## Appeal Decision

**Appeal Ref: APP/T2350/W/20/3251534**

**28 Calfcote Lane, Longridge PR3 3SR**

## Existing and Proposed Block Plans

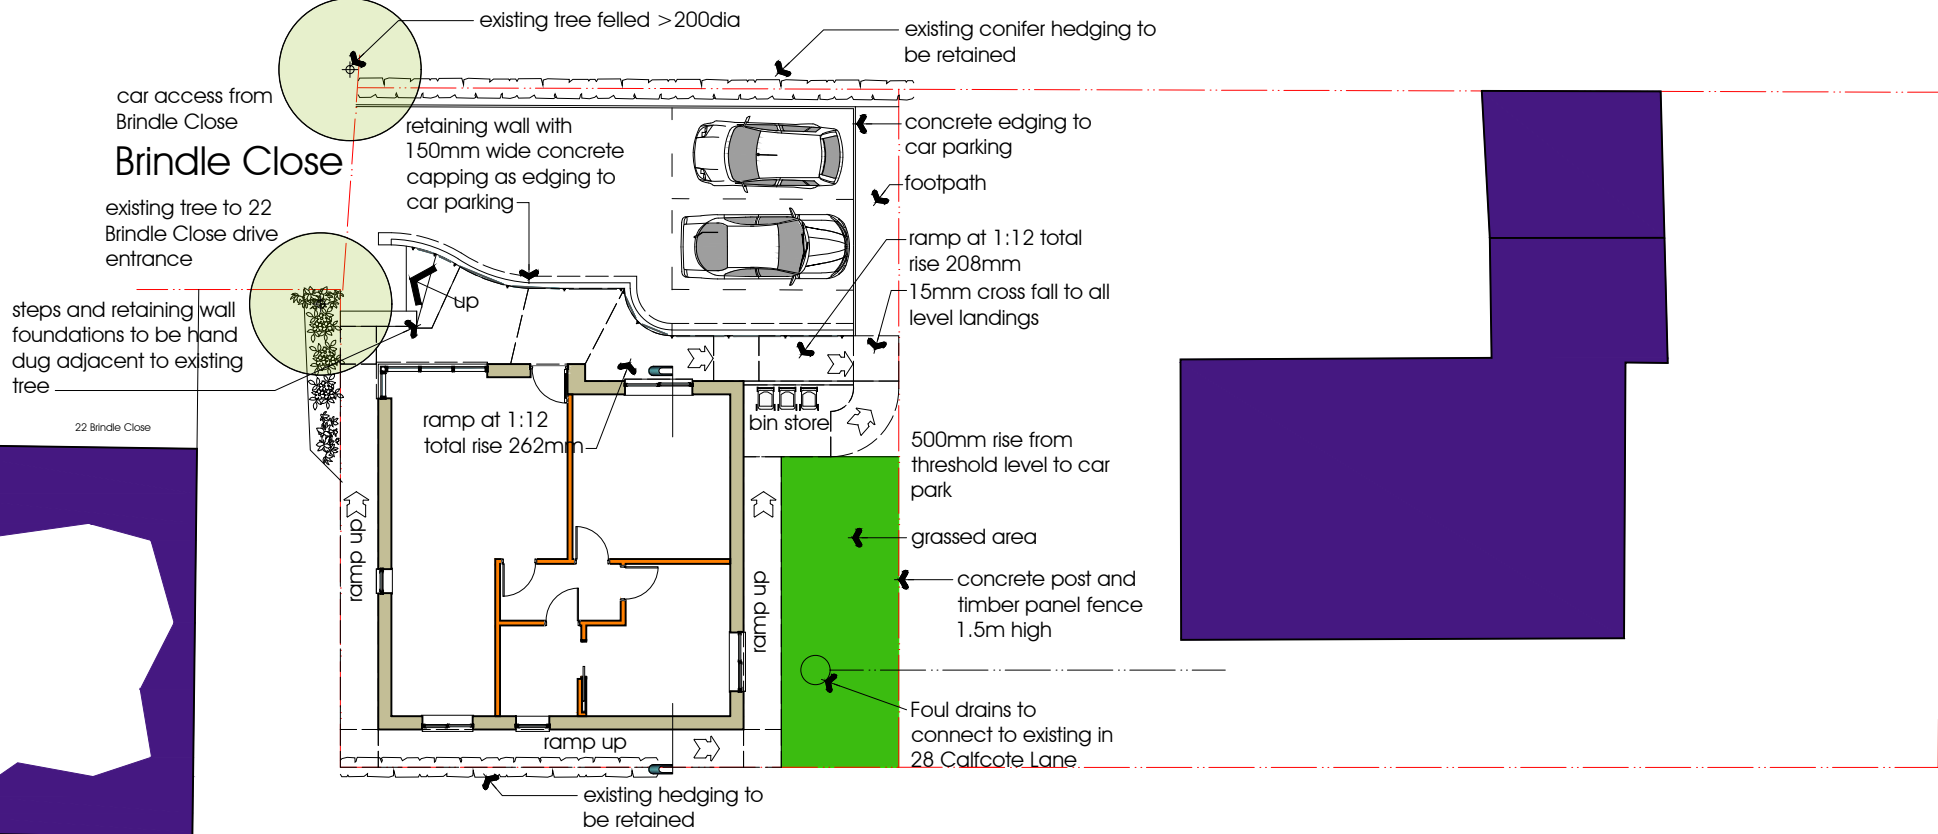
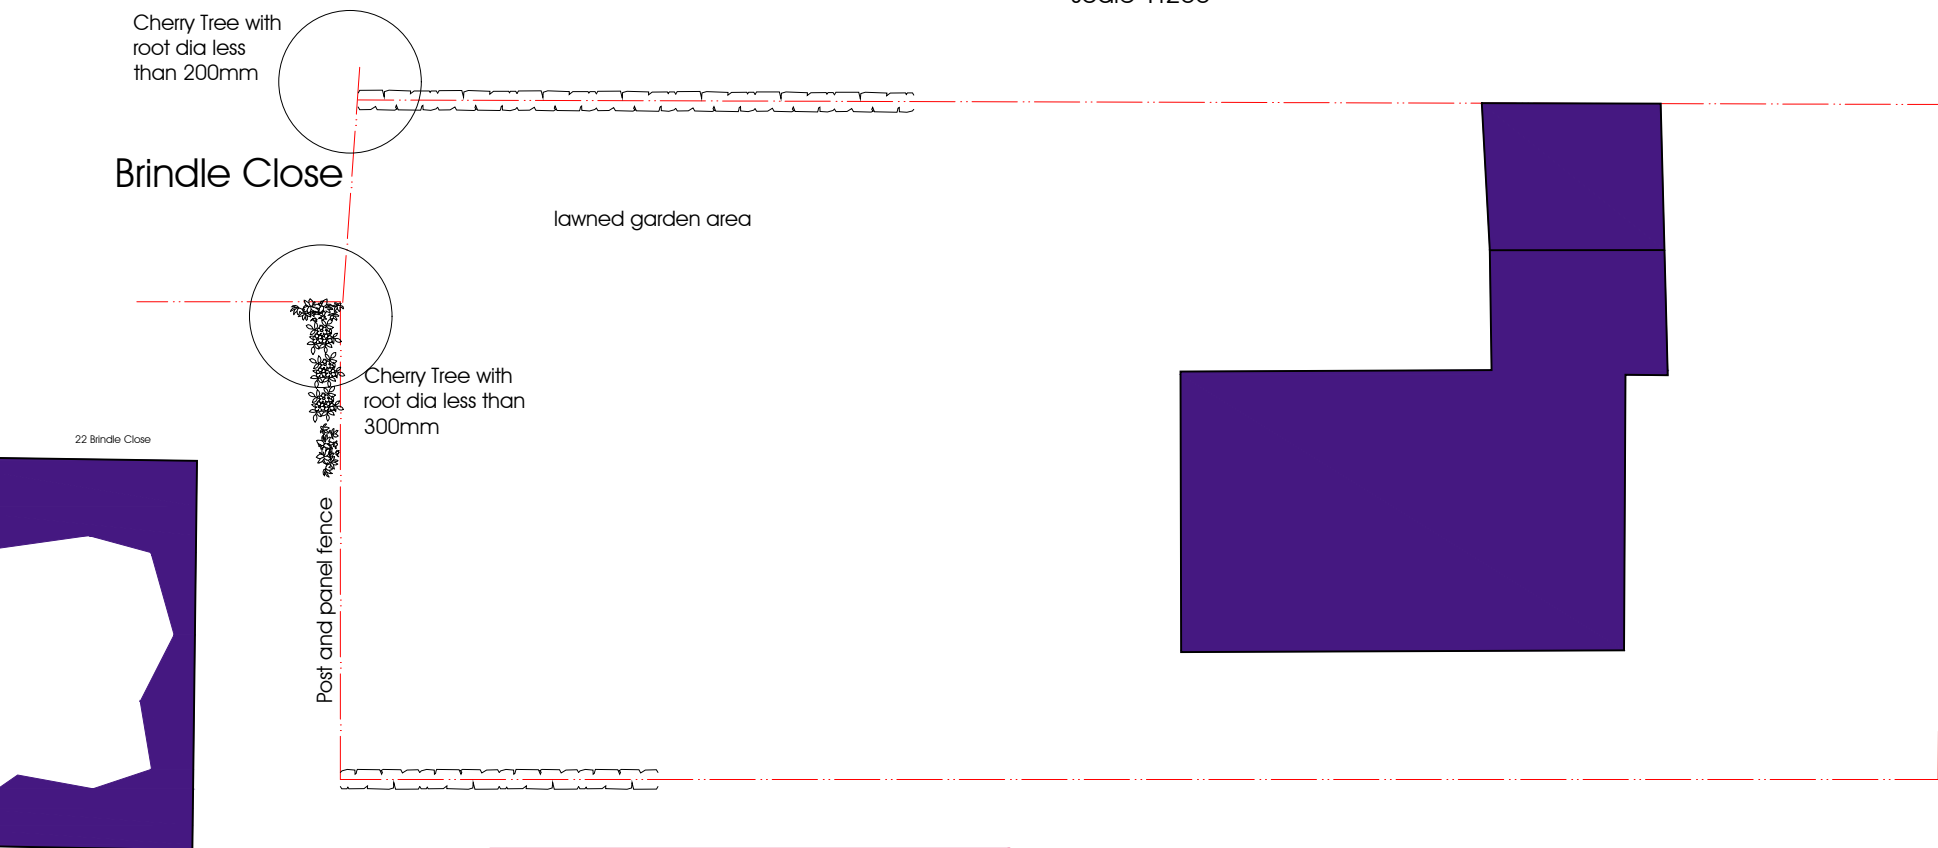
6. The proposal would subdivide the existing garden area of No28 to form a separate plot adjacent to the turning head of Brindle Close and accessed directly from it. Consequently, the building would be mainly viewed in the context of Brindle Close.

7. However, the size of the plot would be much smaller than those typical of the surrounding townscape. Although the position of the building would substantially retain an open vista looking towards the head of the cul-de-sac, the building would be in close proximity to the plot boundaries which would necessarily be retained at height to protect the living conditions of neighbouring residents.

8. When taken with the orientation and short distance of the proposed principal elevation to the elevated side garden boundary of 26 Calfcote Lane and the close proximity to built development on three sides of the dwelling, the proposal would appear cramped and hemmed-in within the site. This arrangement would contrast sharply with the consistent pattern of deeper plots of the nearby residential properties and introduce a higher density of development that would run contrary to the layout and grain of local development. In turn, this would fail to achieve a sense of spaciousness about the building which is a positive characteristic of development in the locality.
